Your Ref: OWQC23764
Our Ref: EP/58/19/HH
Please ask for:
Mr Z Denton

Two storey side extension and single storey front extension, including alterations to external material cladding.

58 Roundstone Crescent East Preston

Thank you for your internet comments made on 25th July 2019 which has been recorded as **'an objection'** with the comments as follows:

Drawing  
**Proposed Drawings**

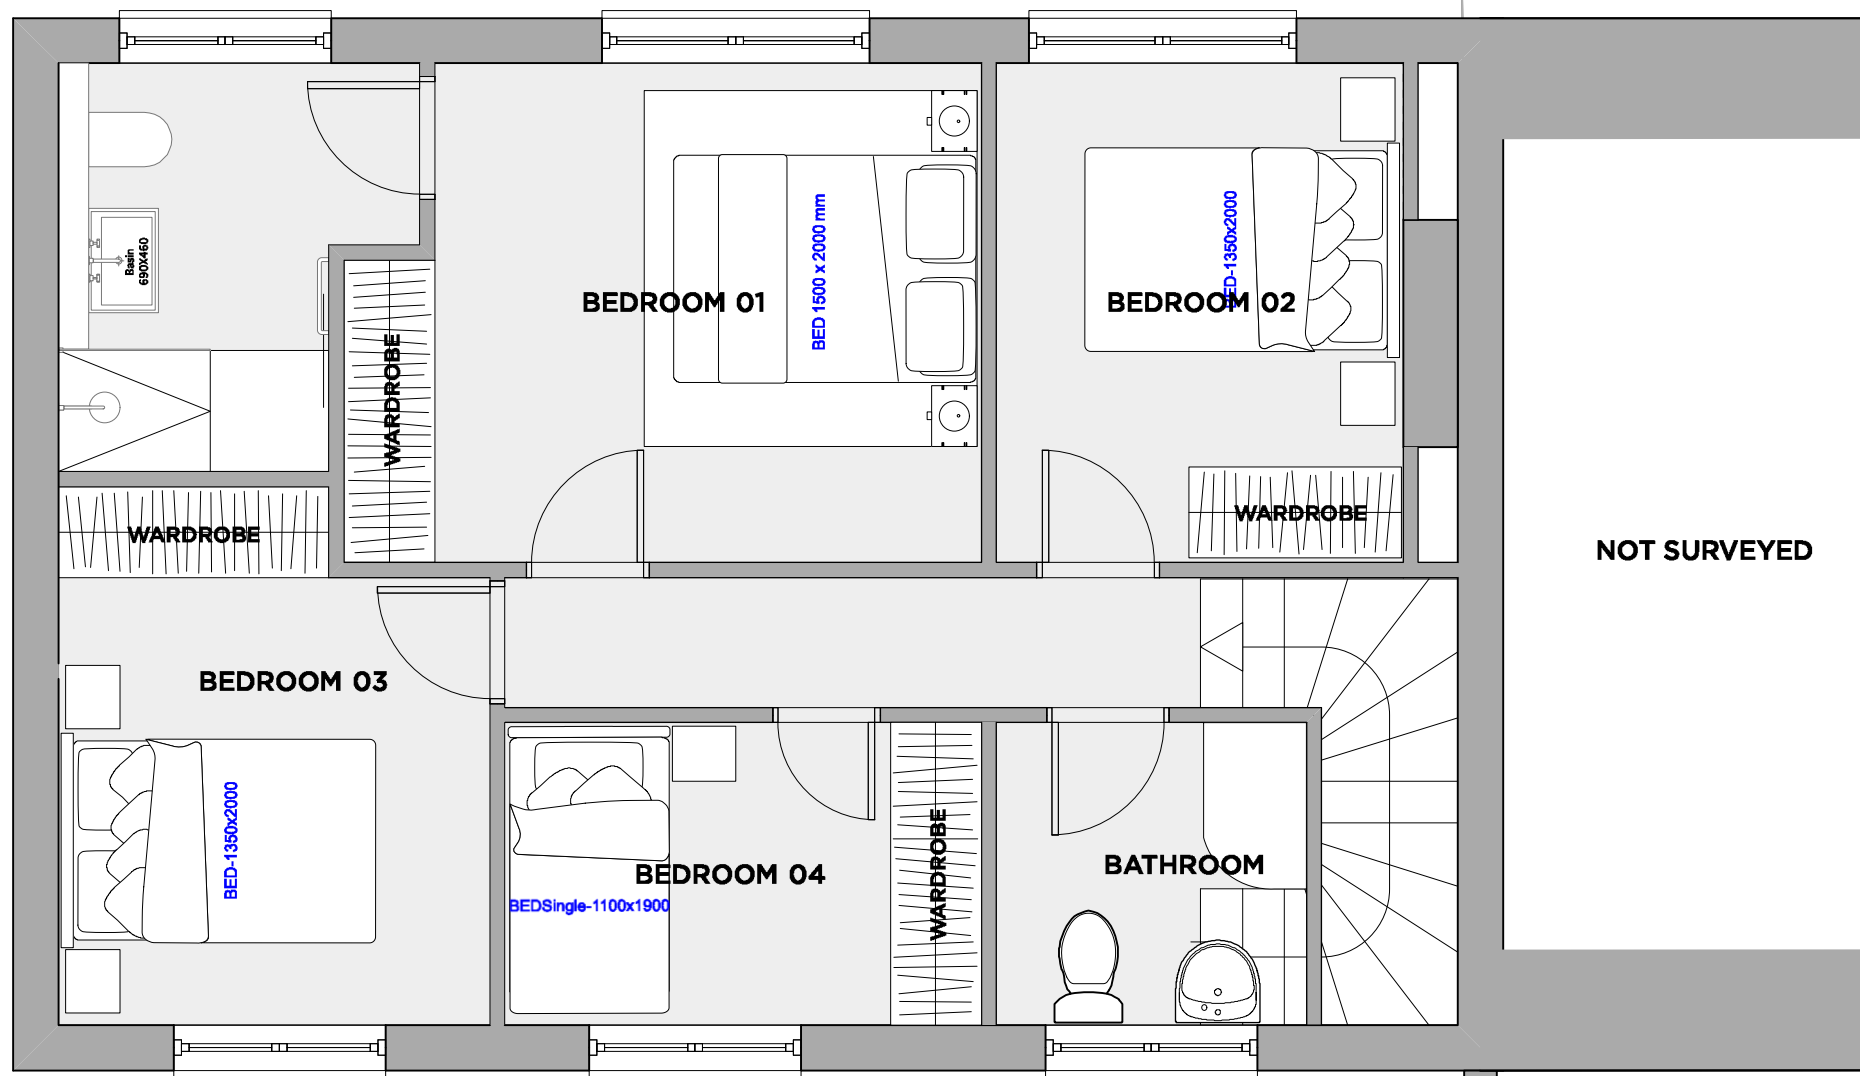
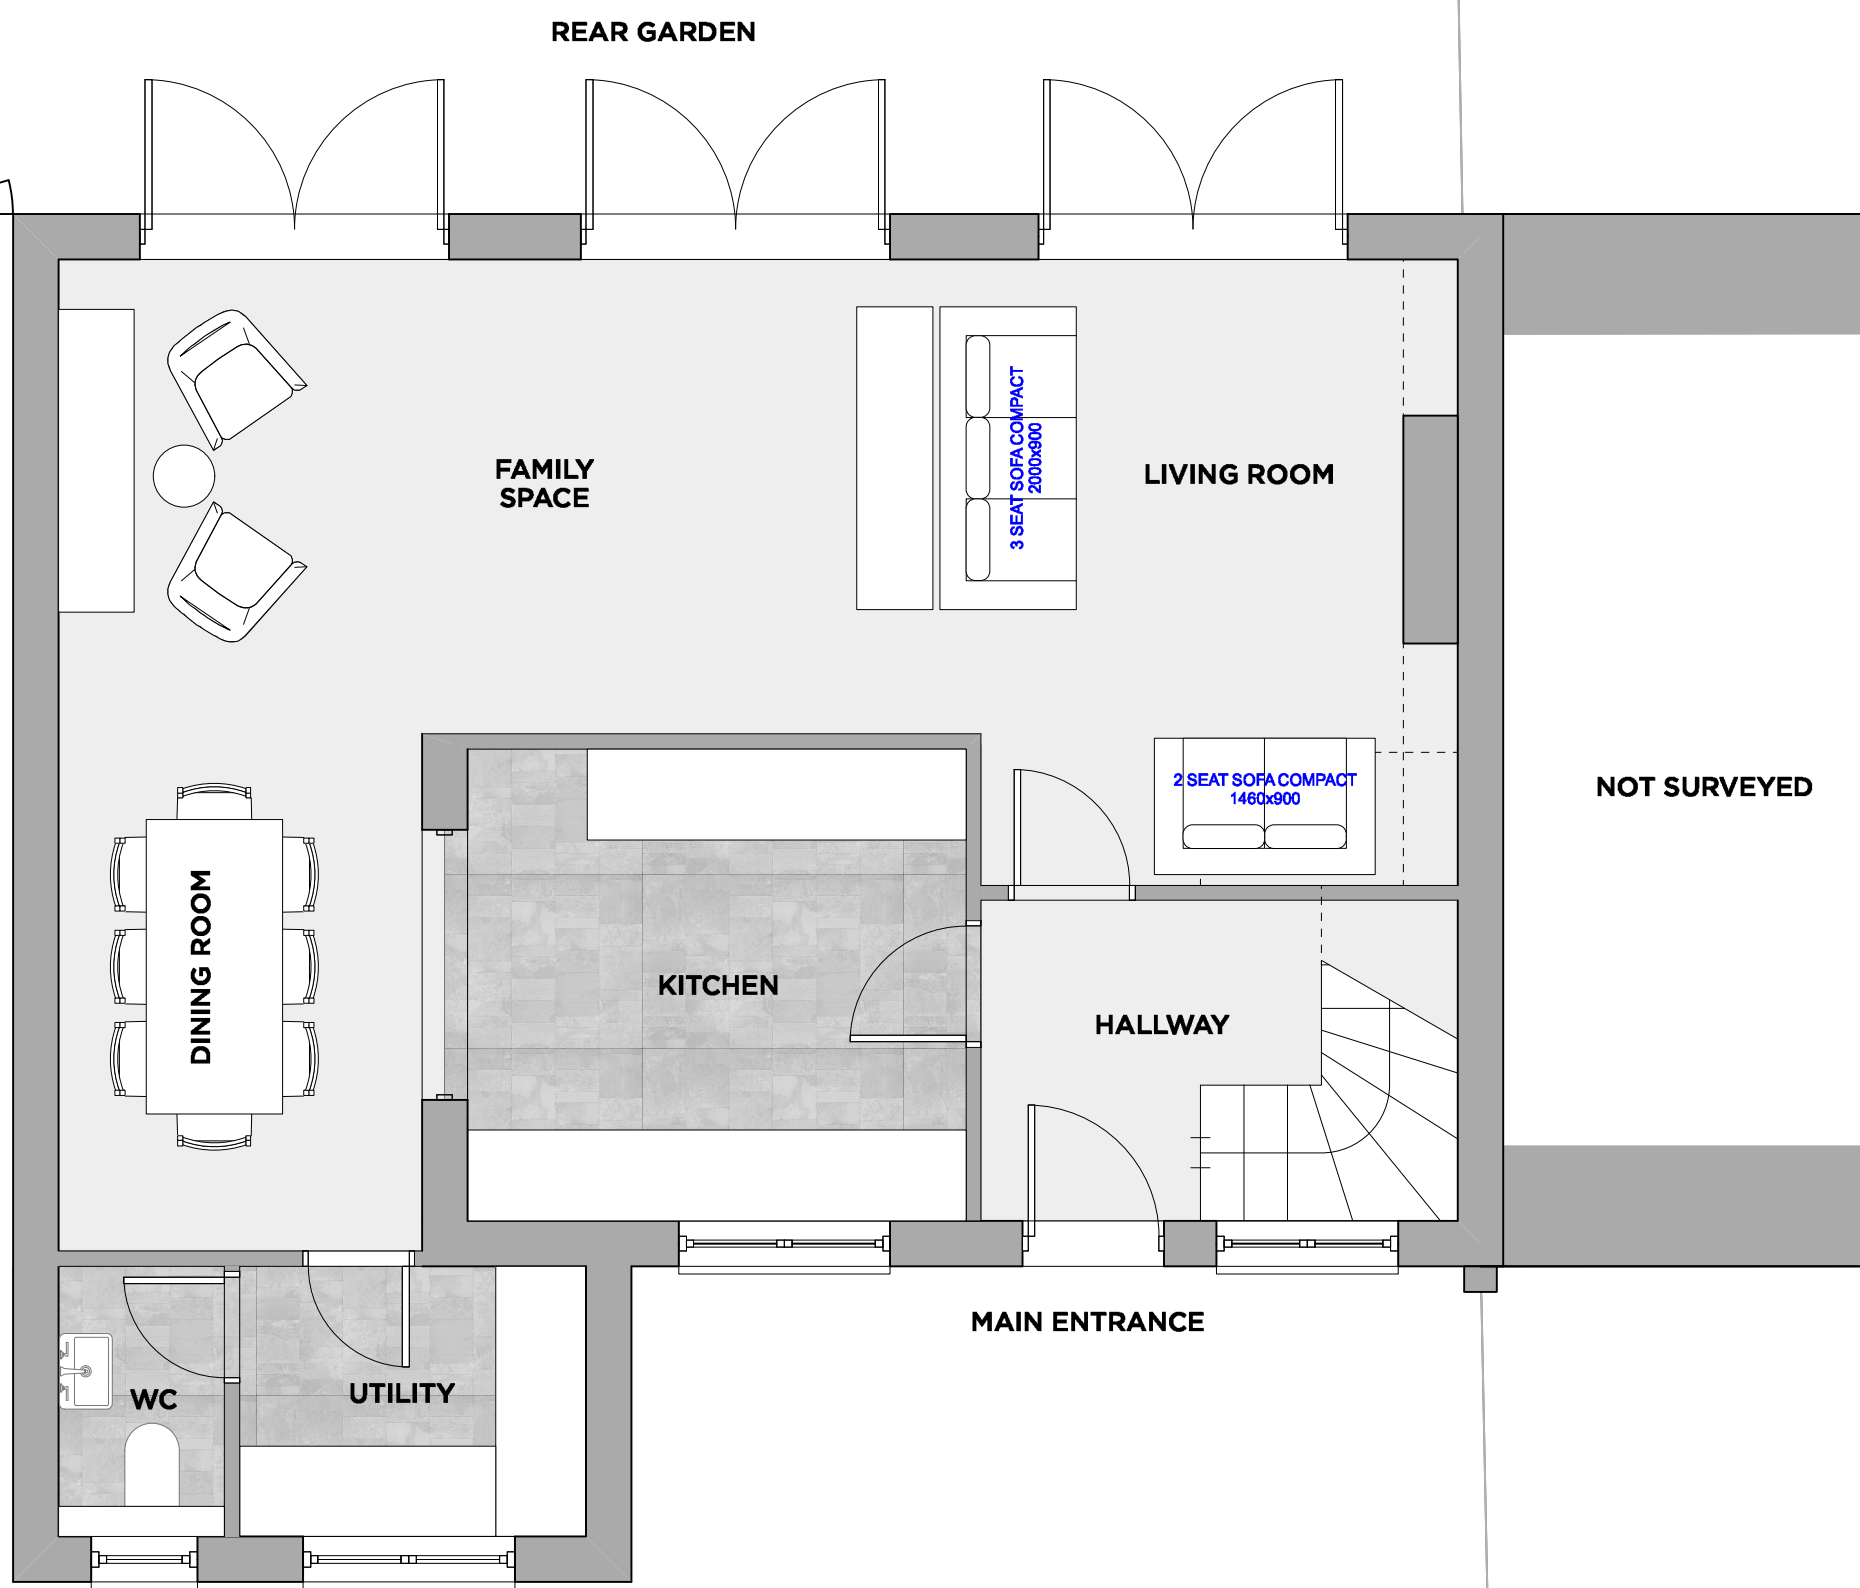
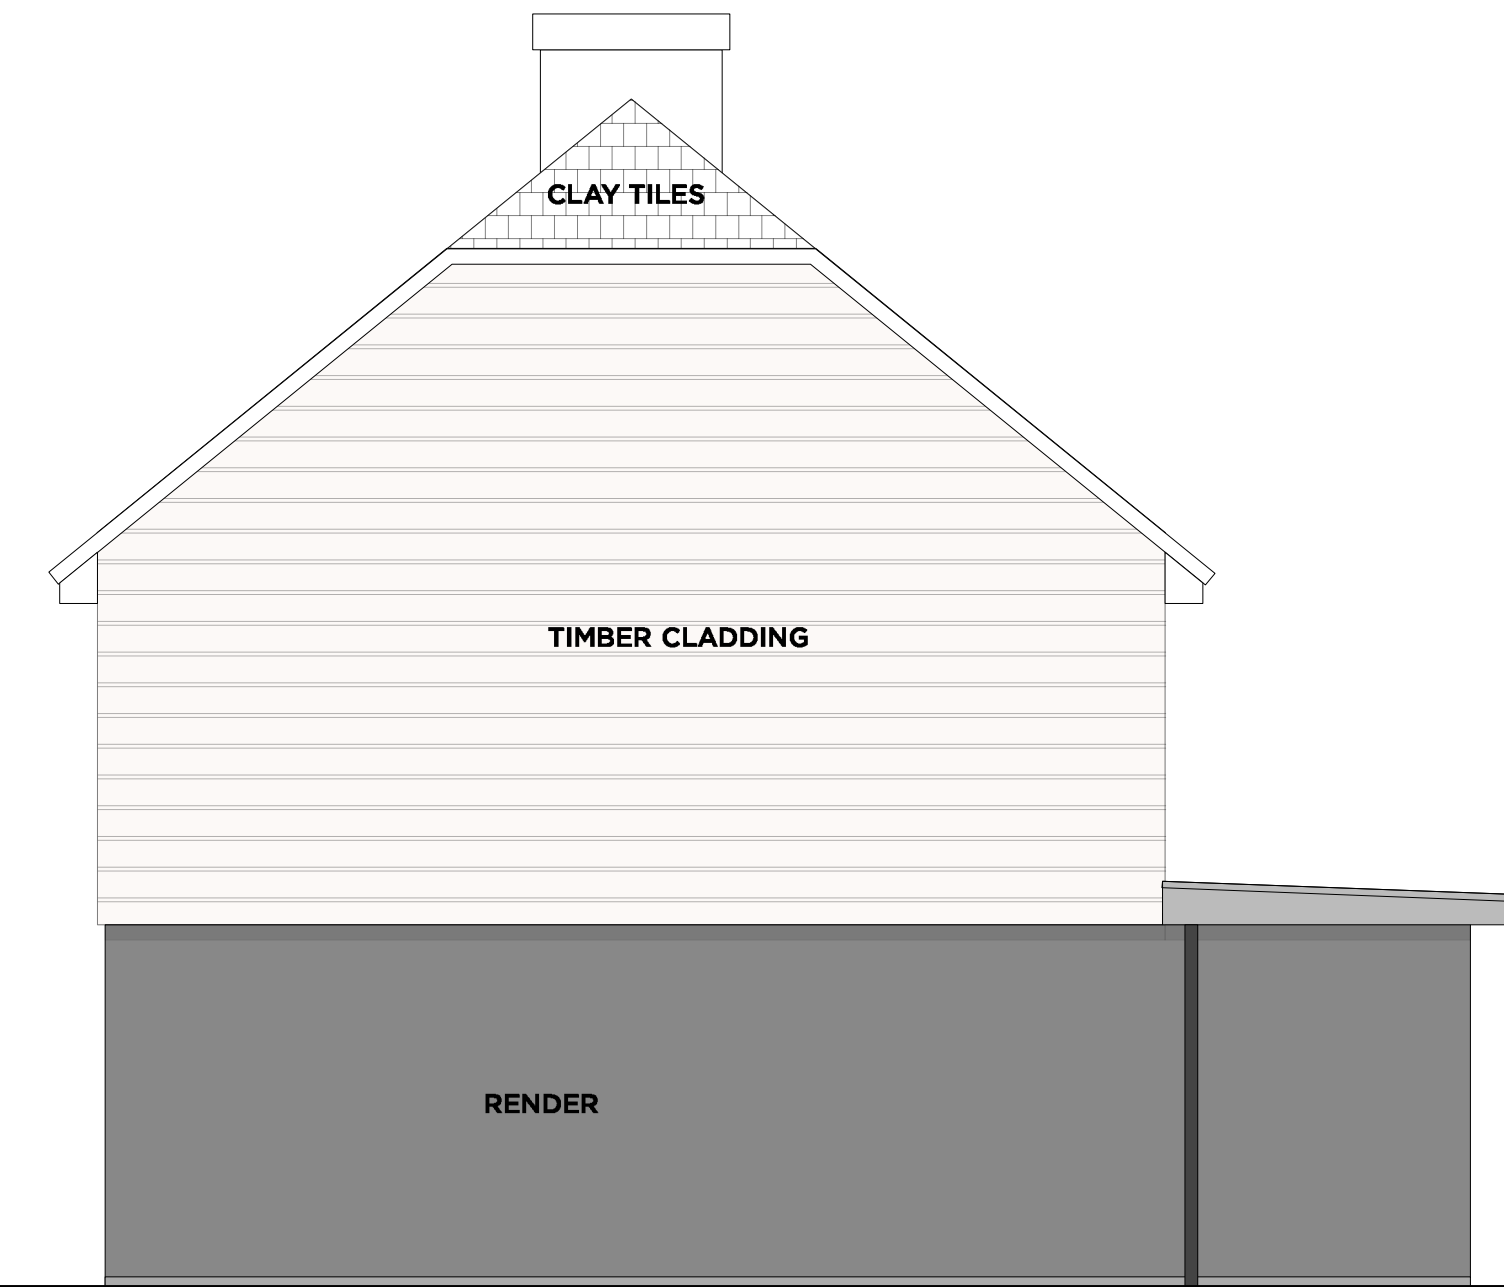
The committee agreed not to object to the proposed building works but it also agreed it would object to the proposed materials.

The Application form states "Ground floor brick to be rendered in a dark grey colour. First floor tiles to be replaced with horizontal timber cladding." This scheme is not in keeping with the local streetscene and is therefore deemed to be contrary to Policy D DM1.1 as it does not reflect "the character of the site and the surrounding area, in terms of [...] building materials (colour, texture), landscaping and design features."

The proposed materials are also contrary to the East Preston Neighbourhood Plan as Policy 1: Housing - General Principles, section 4.16 says extensions "should harmonise with other houses in the road in scale, design and materials."
